## **SSD-65729209 WALLGROVE BUSINESS HUB**

I refer to the Department's email of 19 September 2024 regarding the Environmental Impact Statement (EIS) for State Significant Development SSD-65729209 40 The Retreat, Bringelly for 'Construction and operation of mixed-use residential development within the Western Sydney Aerotropolis' at 40 The Retreat, Bringelly (Lot 272 DP 803167) in the Liverpool City Council local government area (LGA). Submissions need to be made to the Department by 16 October 2024.

Figure 10: Architectural Site Plan (Source: DKO DA Documentation)

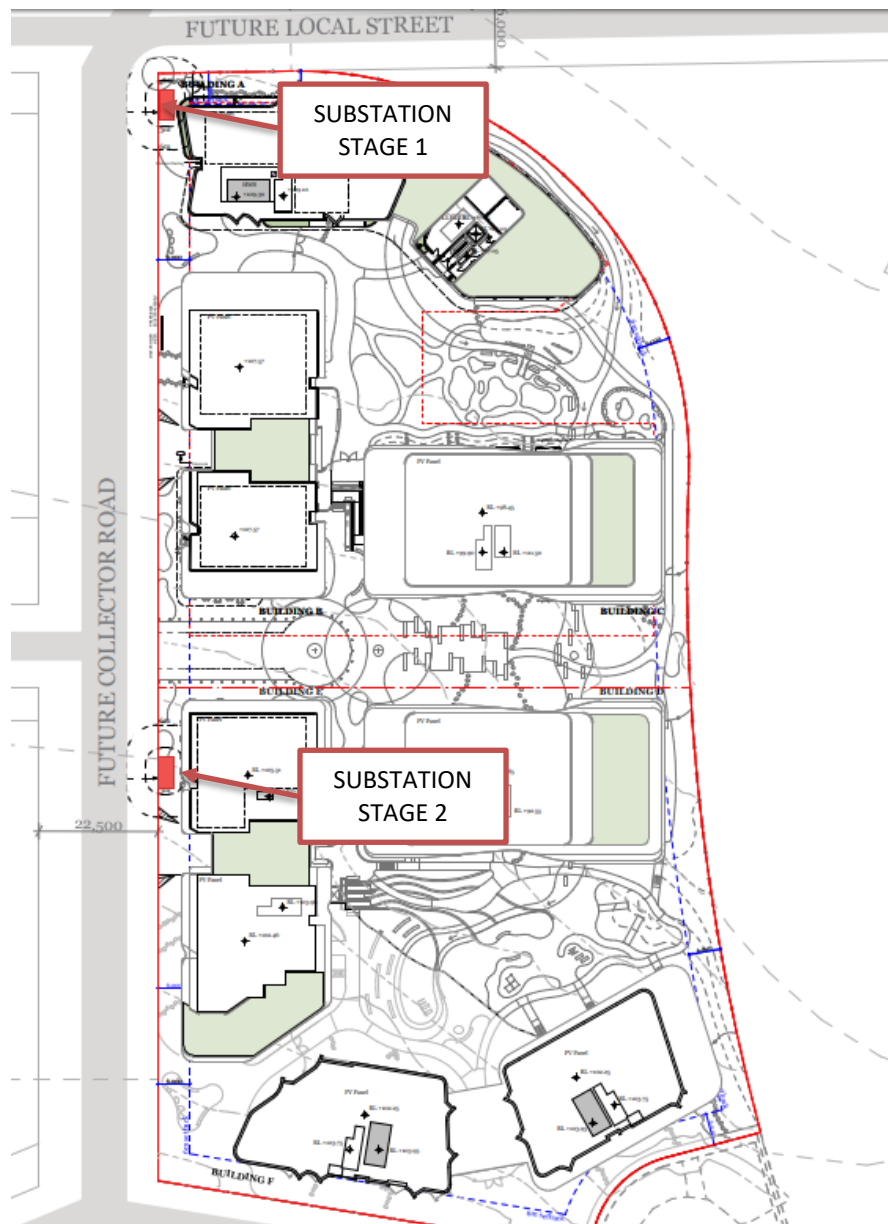
The below extract of the Site Plan shows provisions for two substations with frontage to the 'Future Collector Road'.

Any required padmount substation/s will need to be located within the property (in a suitable and accessible location) and be protected (including any associated cabling not located within a public road / reserve) with an appropriate form of property tenure as detailed in the attached copy of Endeavour Energy's 'Land Interest Guidelines for Network Connection'.

Generally it is the Level 3 Accredited Service Provider's (ASP) responsibility (engaged by the developer) to make sure substation location and design complies with Endeavour Energy's standards the suitability of access, safety clearances, fire ratings, flooding etc. If the substation does not comply with Endeavour Energy's standards, the applicant must request a dispensation.

If any part of the building encroaches the restriction for fire rating for the padmount substation, the applicant will need to provide Endeavour Energy with an engineer's certificate identifying that all external surfaces of the building within the fire rating zone meet the appropriate fire rating as per Endeavour Energy's terms for the restriction Endeavour Energy's Mains Design Instruction MDI 0044 'Easements and Property Tenure Rights'.
